SUBMISSIONS ON MP 08_0241 100 MOUNT STREET NORTH SYDNEY – AGENCY AND PUBLIC SUBMISSIONS

PART A – AGENCY SUBMISSIONS

PART A – AGENCY SUBMISSIONS

Diagrams 20 and 21 – Presentation of Upper Tower form and proposed and compliant Walker Street setbacks (Source: PPR)

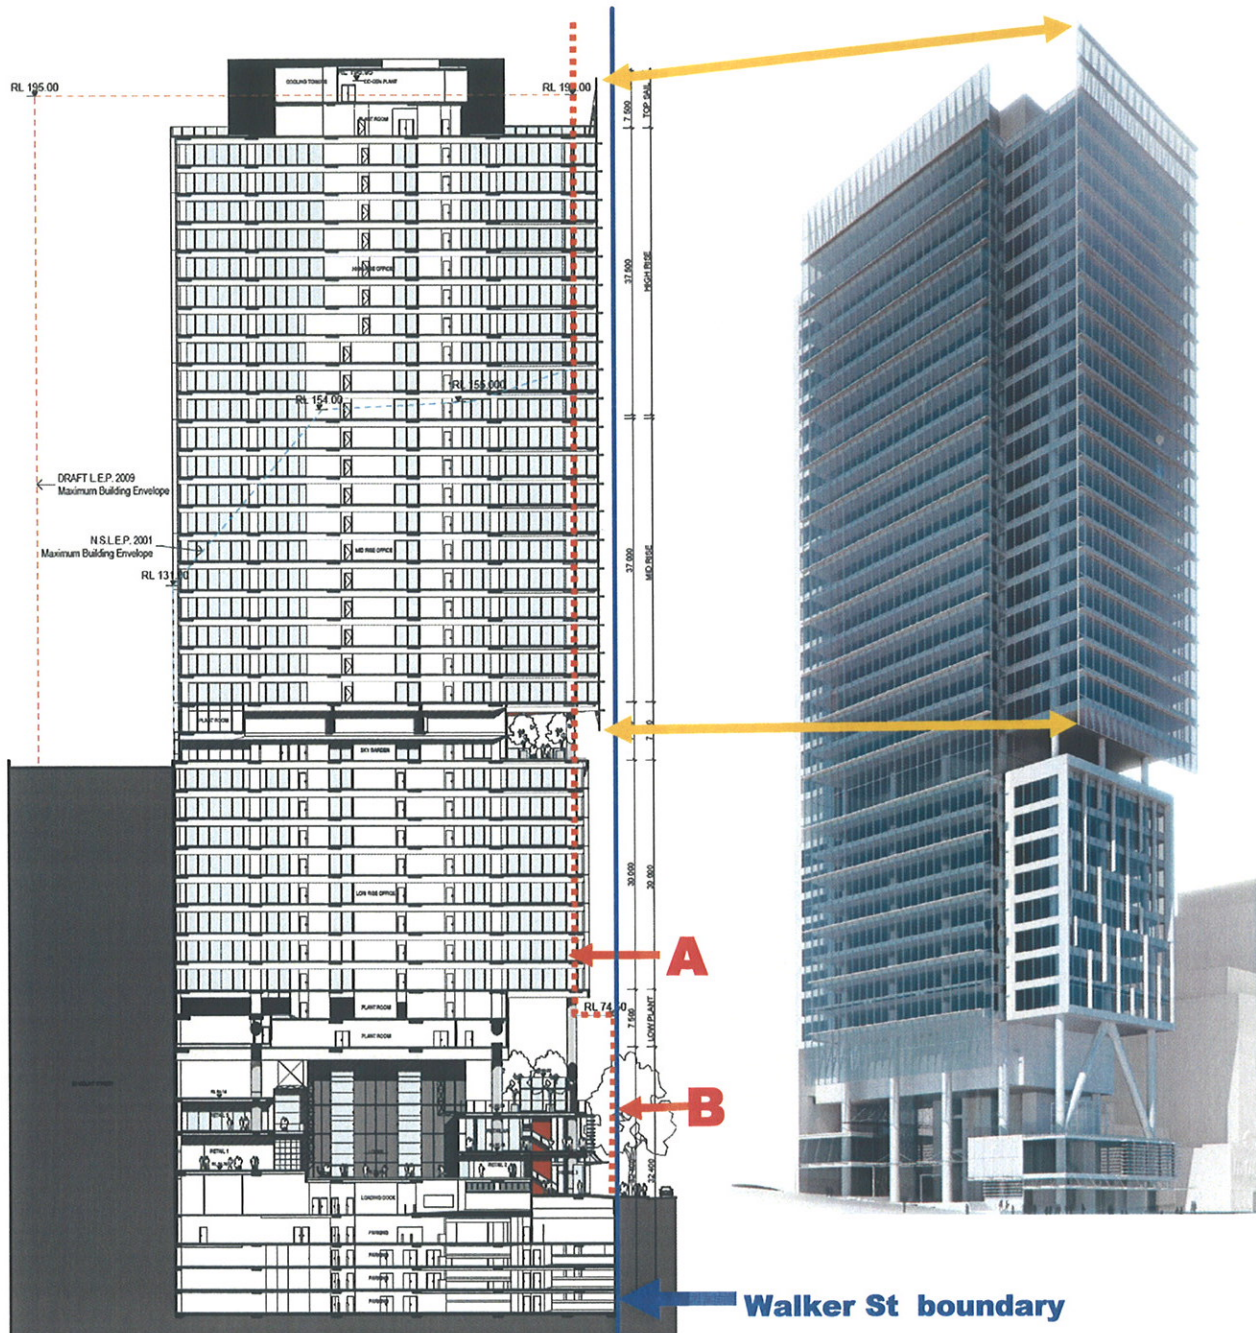
<ul style="list-style-type: none"> Building setback above level 22. 	<ul style="list-style-type: none"> The setback above Level 22 has been increased. Refer to discussion in Section 4 of the PPR.
		<ul style="list-style-type: none"> Lack of information to enable solar assessment. 	<ul style="list-style-type: none"> A detailed analysis of overshadowing upon the area surrounding the North Sydney Centre, refer to Appendix E. A discussion of potential impact is included in Section 3 of the PPR.
		<ul style="list-style-type: none"> Request meeting with proponent to discuss whether a cinema is viable 	<ul style="list-style-type: none"> Various cinema operators were consulted and as outlined in the letter attached at Appendix M, one operator made an offer for floor space at a rate of \$275/m² gross, with the area they require being a minimum 2000m². The architect generated a potential design to locate a small cinema complex in the lower levels of the building, see Appendix M. This design included two cinemas of approximately 90 seats and 130 seats with a maximum area of approximately 530m². Based upon the inability to design in an area of 2000m² and the offer being less than that required to be viable (the development needs approx. \$1000/m² gross to be viable which can be obtained with other retail uses), locating a cinema in the development is not feasible.

Diagrams 24 and 25 – Impact on views at top level of Beau Monde from the LEP 2001 envelope (BLUE), the Draft LEP envelope (RED) and the proposal (Source: PPR)

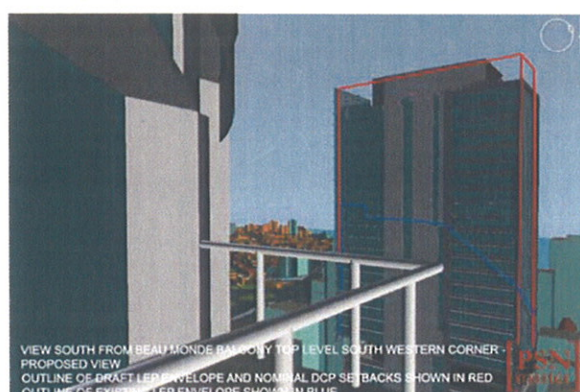
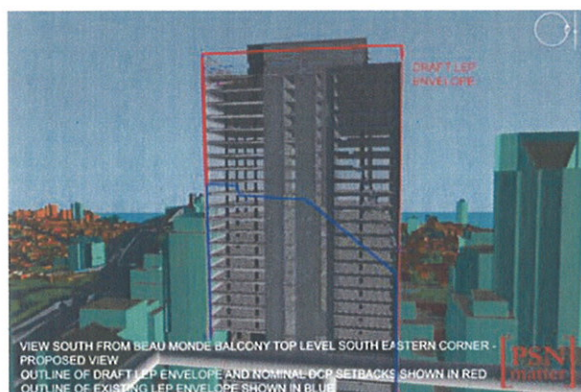
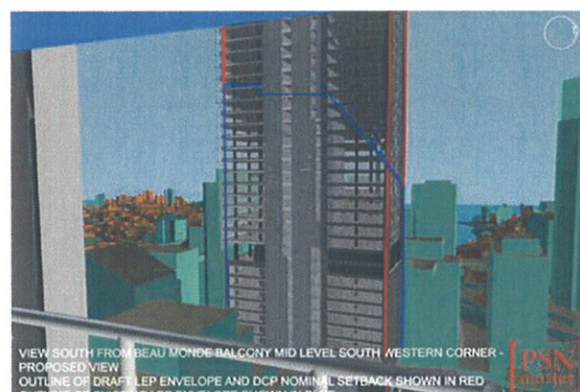
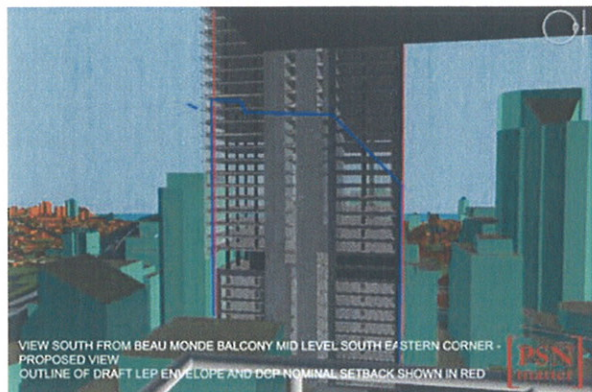
Local Residents	<ul style="list-style-type: none"> ▪ View loss from Beau Monde. 	<ul style="list-style-type: none"> ▪ An amended view loss assessed is included in Section 7.4 of the PPR. The analysis finds that there is some view loss relative to that existing, but in the circumstances the extent of view loss is considered reasonable.
		<ul style="list-style-type: none"> ▪ Inadequate landscape planting. 	<ul style="list-style-type: none"> ▪ The proposal will include planting of the street directly adjacent to the property frontage with a species consistent with that desired by Council and recommended in the Wind Impact Study.
		<ul style="list-style-type: none"> ▪ Wind impact. 	<ul style="list-style-type: none"> ▪ A wind impact study that assesses the cumulative impact of the proposal in conjunction with that at No.88 Walker Street has been prepared by Windtech, refer to Appendix G. The study includes recommendations, that will be included as conditions, to ensure that wind impact is restricted to reasonable levels. A summary of the conclusion is included below: <i>“The results of this wind tunnel study indicate that most of the outdoor areas of the various developments, including all ground level areas, will require ameliorative treatments to be implemented to result in acceptable wind conditions. Many forms of treatments have been investigated in this study to treat the adverse winds affecting the outdoor areas of the proposed development sites. A set of treatments have been recommended in this report to ameliorate these effects, and are summarised as follows:</i> <ul style="list-style-type: none"> • A strategic layout of densely foliating trees for the ground level areas within and around the two development sites. • The addition of an awning above the street level along Walker Street for the 88 Walker & 77-81 Berry Street development. • The addition of an awning above the street level along the eastern and southern aspects of the 100 Mount Street development. • The addition of wind deflectors/awnings above the street level on the northern and southern aspects of the street linking Denison Street with Little Spring Street (which cuts through the podium of the 88 Walker & 77-81 Berry Street development). • Additional awning along the western aspect of the 88 Walker & 77-81 Berry Street development or the use of evergreen trees along Denison Street. • Strategic placement of portable 1.2m high impermeable screens within and around the Ground Level of the 100 Mount Street development site. • Maintaining existing 1.5m high shrub at the corner of Denison and Mount Streets and the existing 1.2m high Garden Wall at the corner of Denison and Spring Streets. • 1.2m high impermeable balustrades along the perimeter of the two terrace areas on the Restaurant Level of the 88 Walker & 77-81 Berry Street development, and a strategic layout of densely foliating shrubs. • 1.5m high impermeable balustrades along the perimeter of the Level 8 Roof Garden terrace areas of the 100 Mount Street development. • 1.5m high impermeable balustrade along the perimeter of the Level 20 Sky Garden terrace area of the 100 Mount Street development, setback from the edge. A densely foliating tree is also recommended for this area. <i>Note that for vegetation to be effective in mitigating adverse winds, particularly westerly winds which tend to occur predominantly during the winter months for the Sydney region, the trees along Denison Street and Spring Street should be of a densely foliating evergreen species as indicated in the report. With the recommended treatments listed above</i>
